Sunnica Ltd
2 Crossways Business Centre
Bicester Road
Aylesbury
HP18 0RA

21st January 2022

Application for a Development Consent Order for Sunnica Energy Farm

RE: Advice following issue of decision to accept the application for examination

AECOM  
 Unit 1 Wellbrook Court,  
 Gilton,  
 Cambridge, CB3 0NA  
 United Kingdom  
 Telephone (01223) 488000  
 www.aecom.com

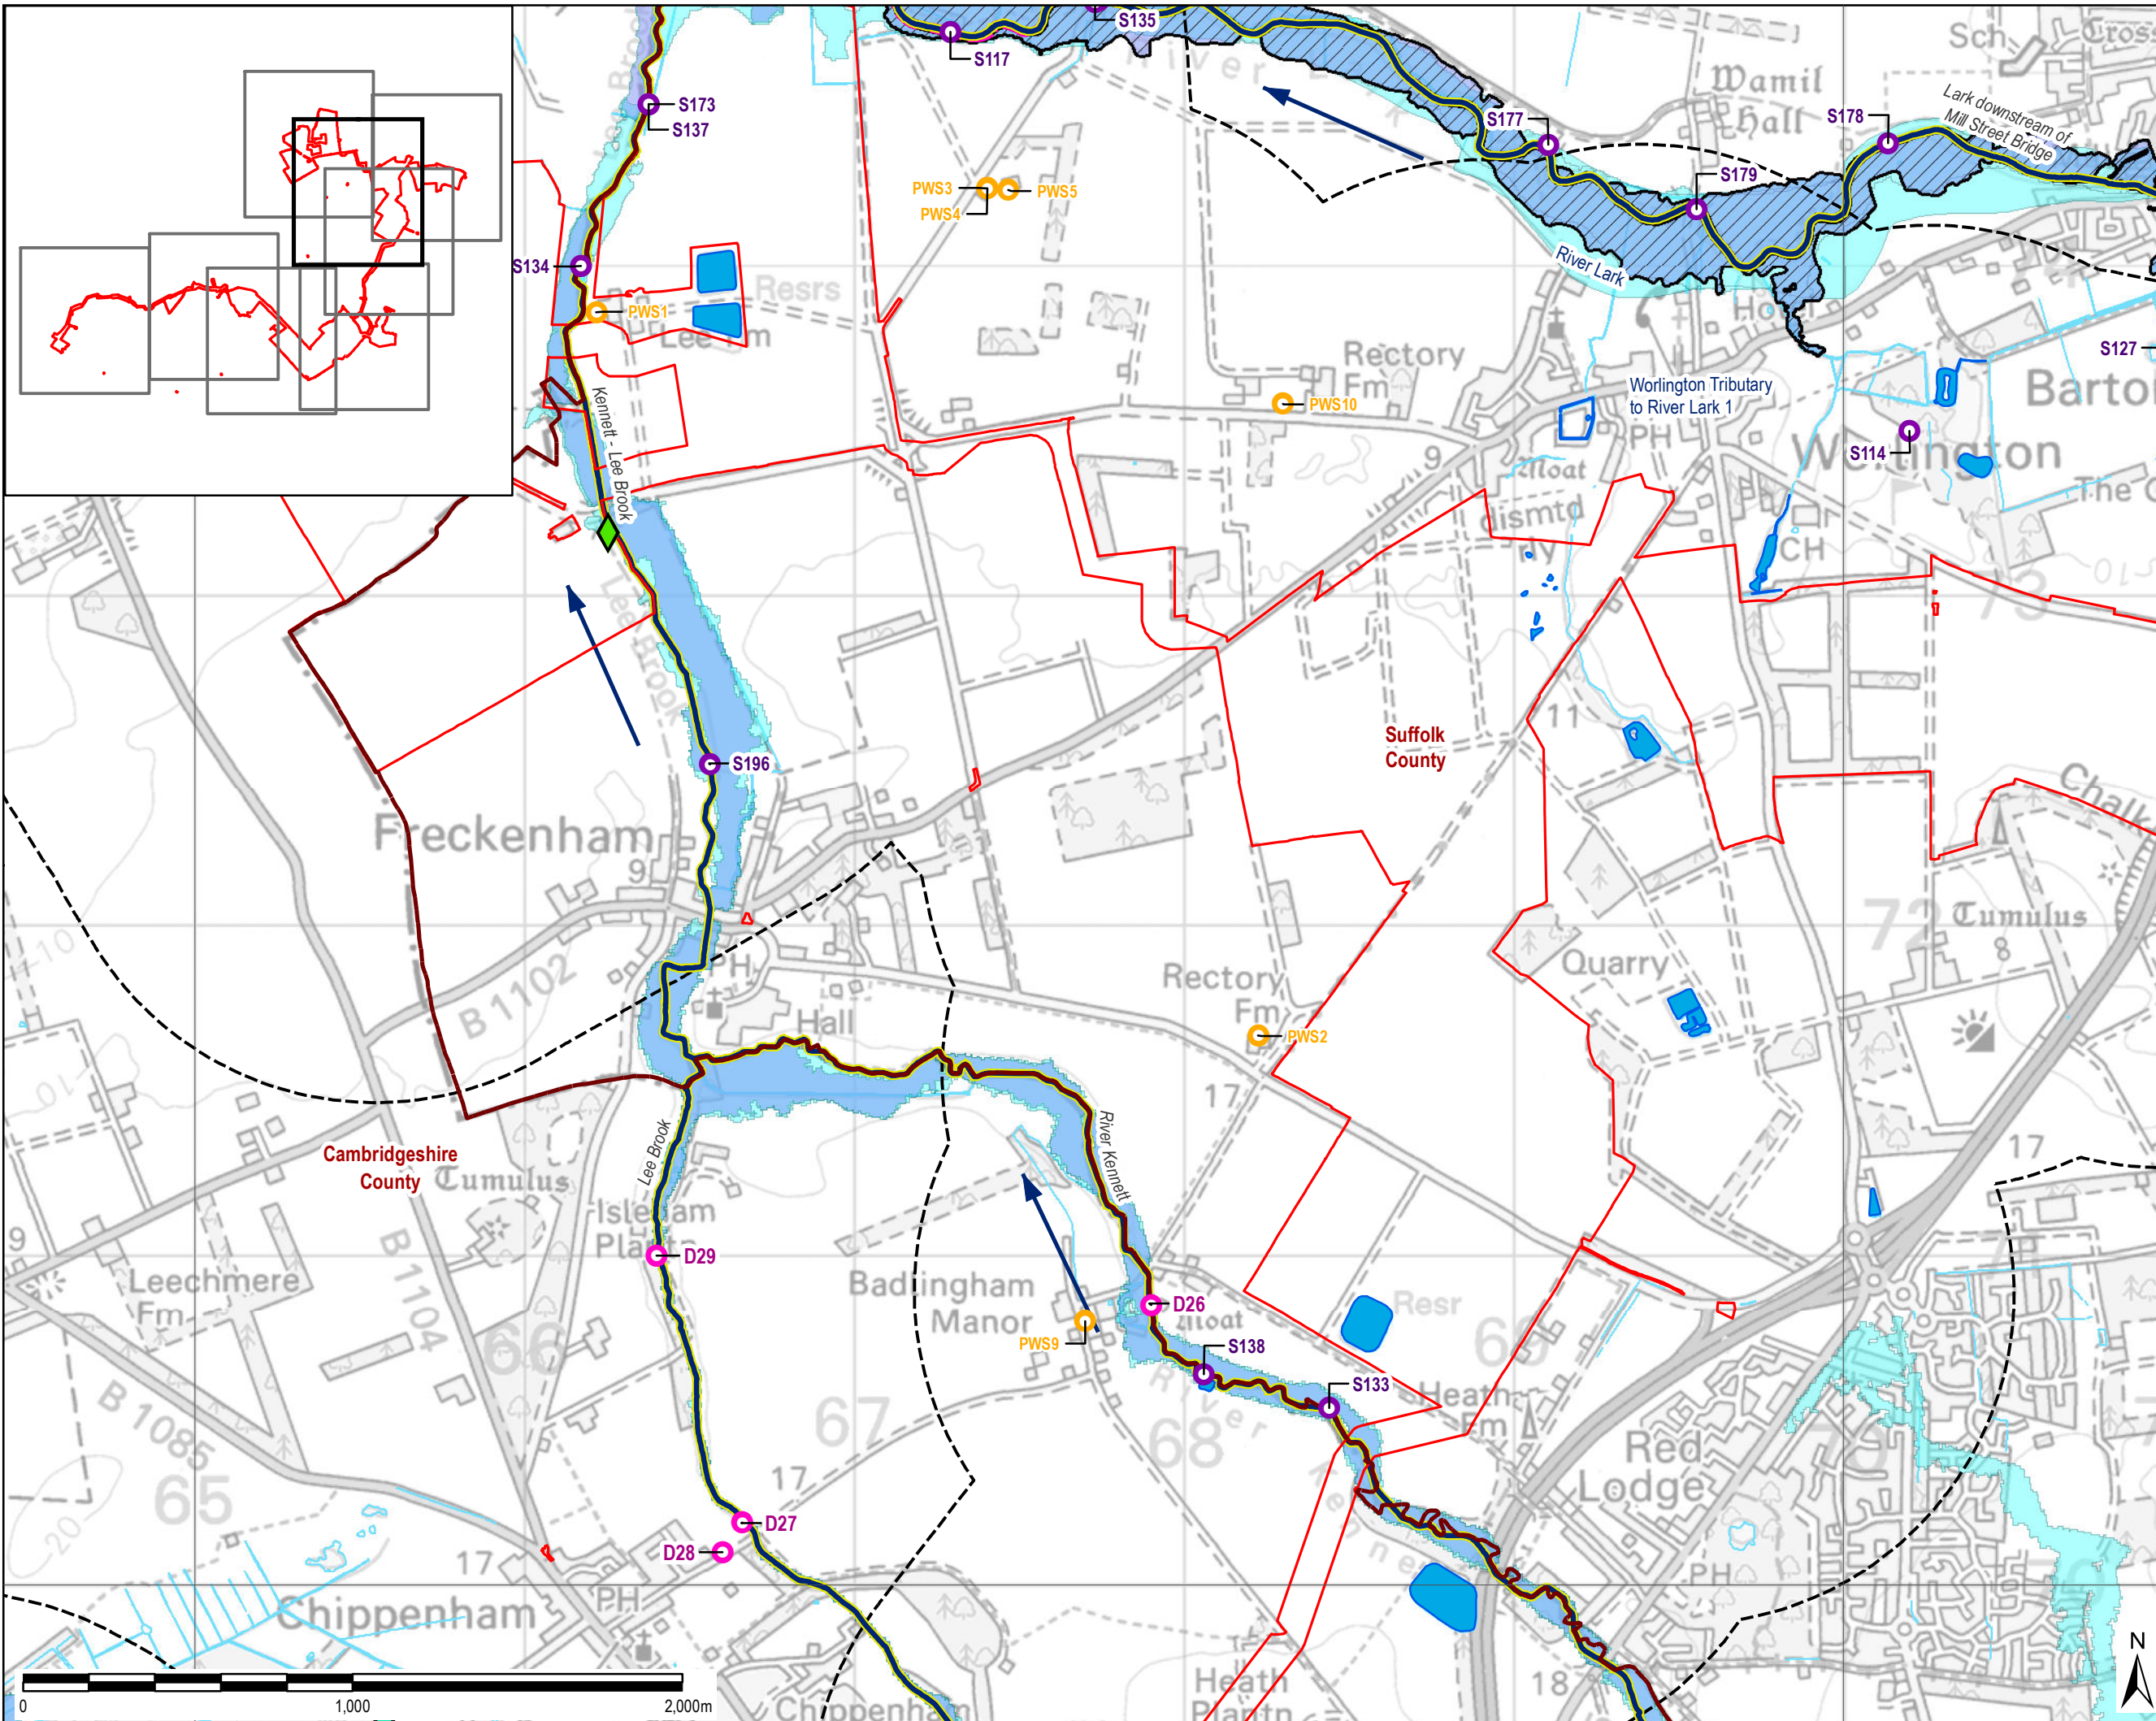
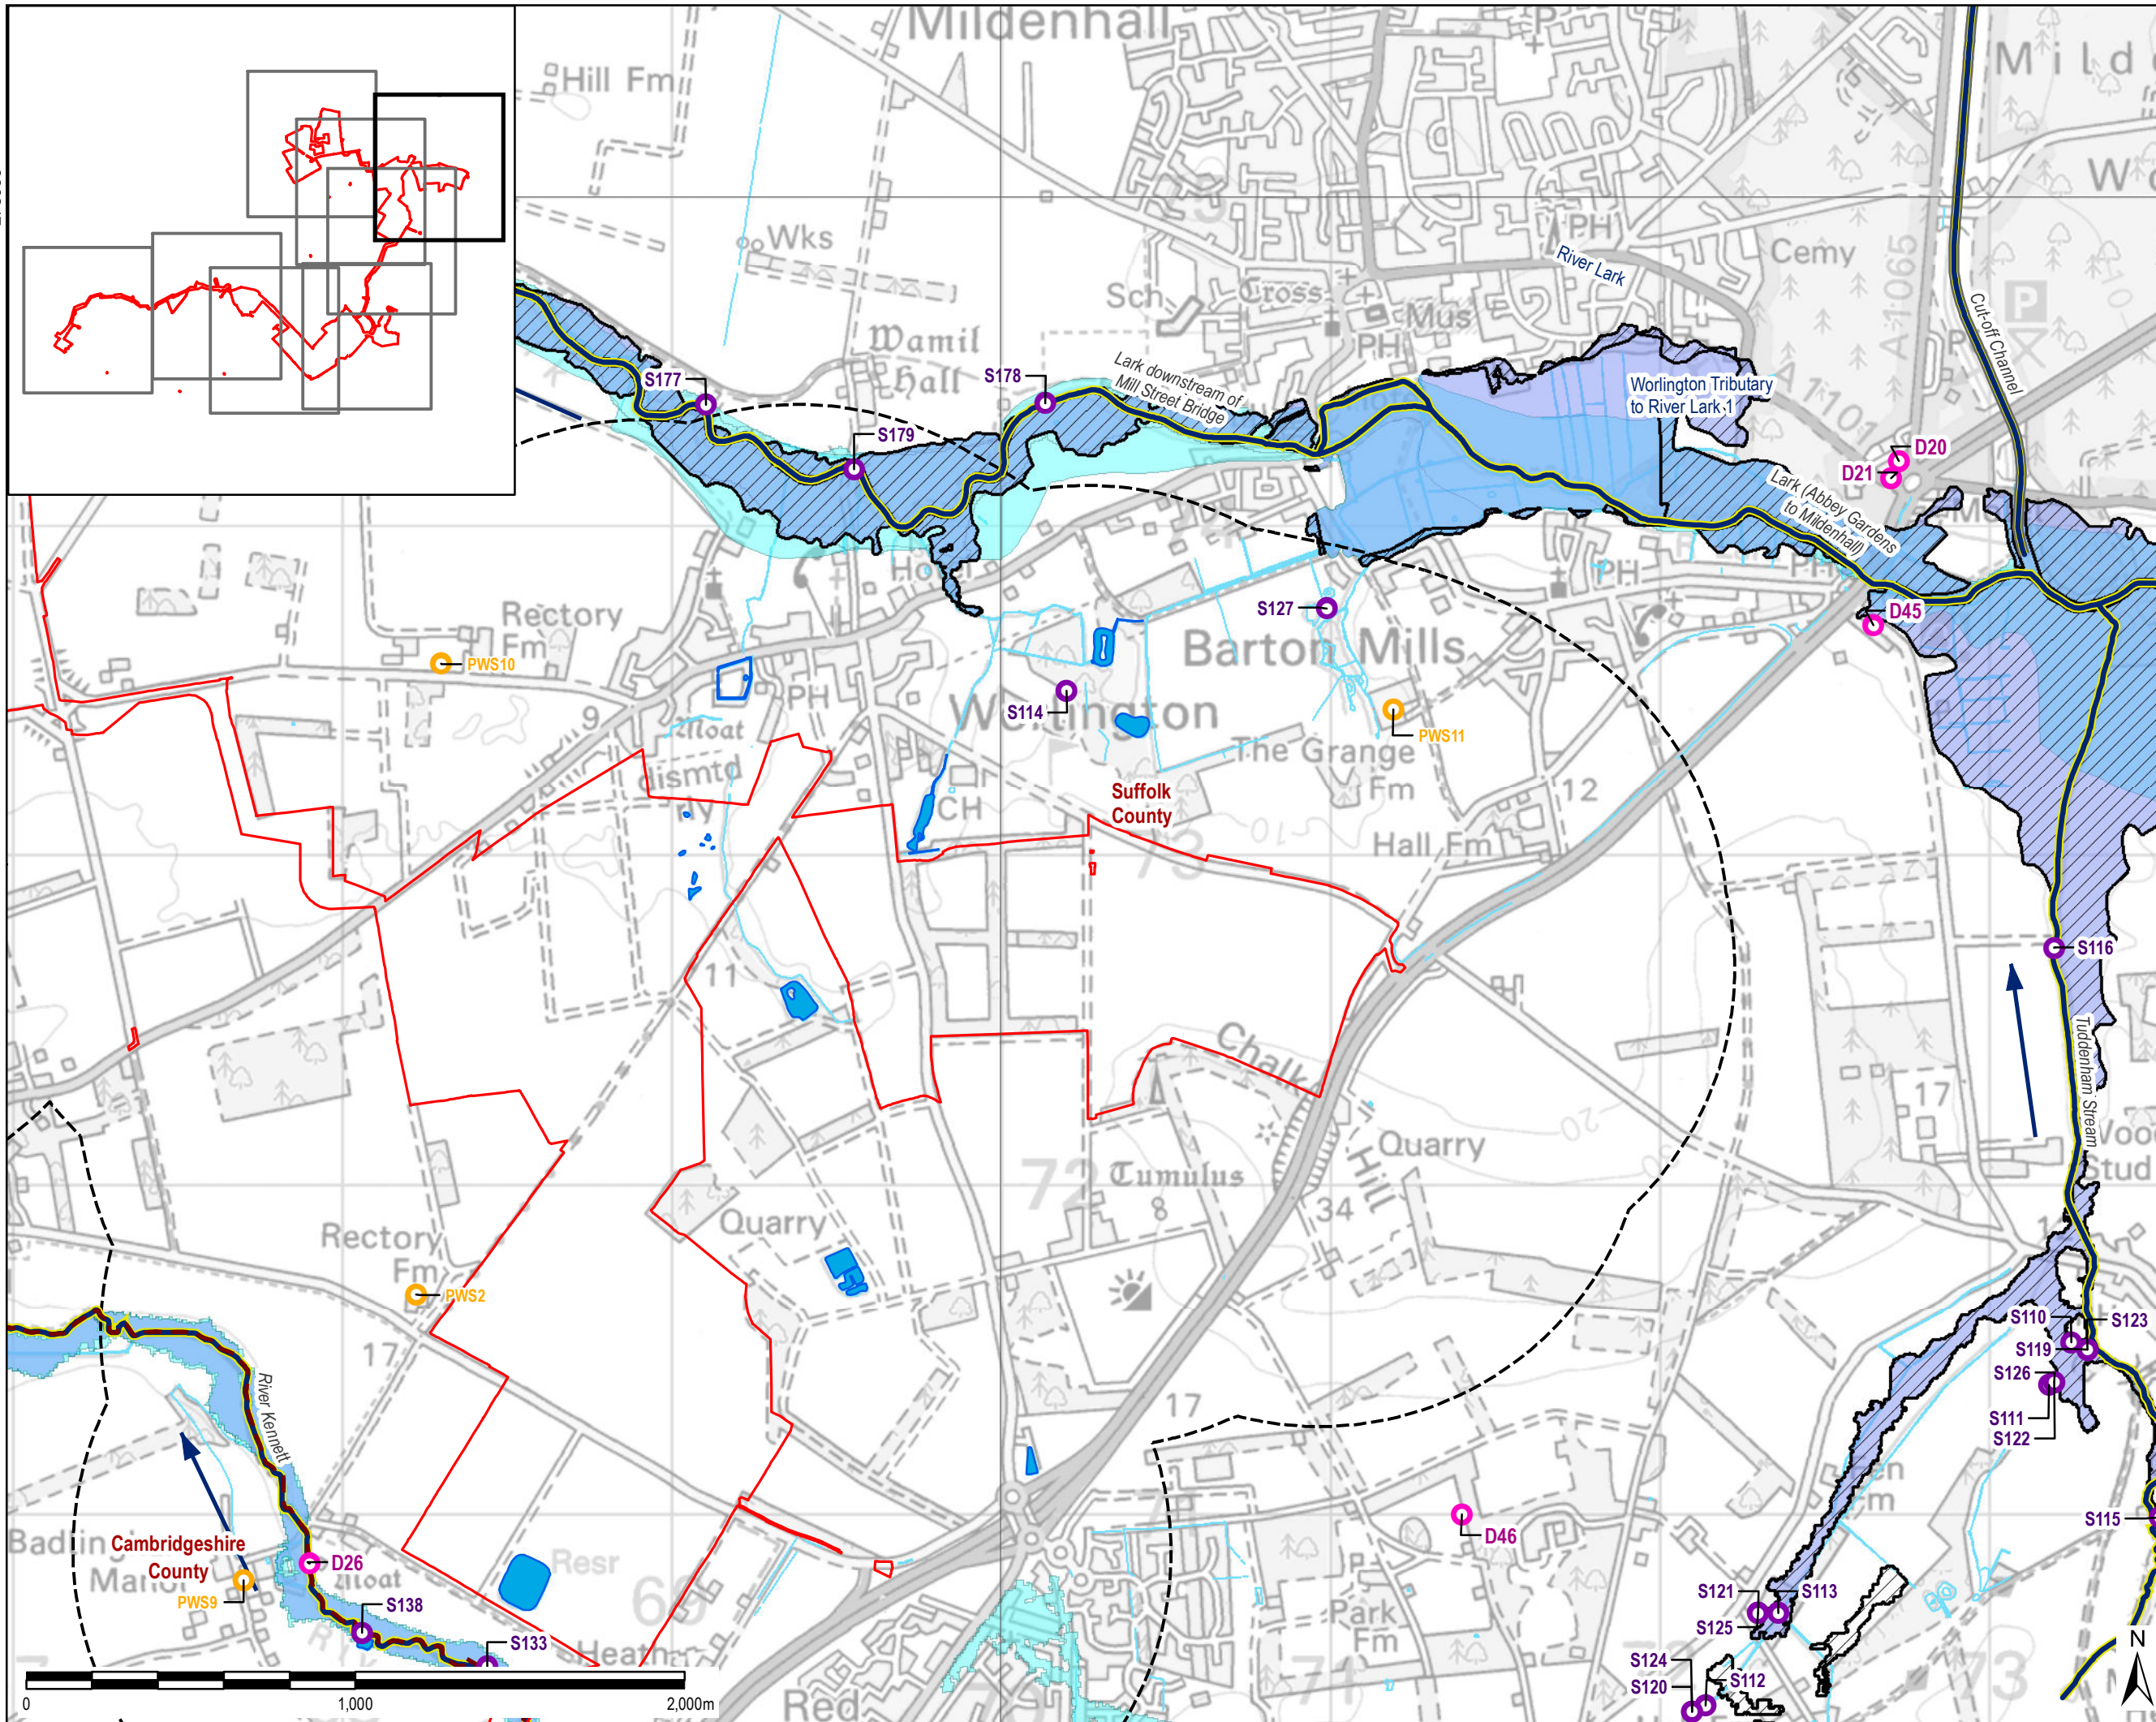
- 1.4.3 Revision 1 of Figure 9-1 of the Environmental Statement [APP-188] is provided to address the advice provided by the Planning Inspectorate.
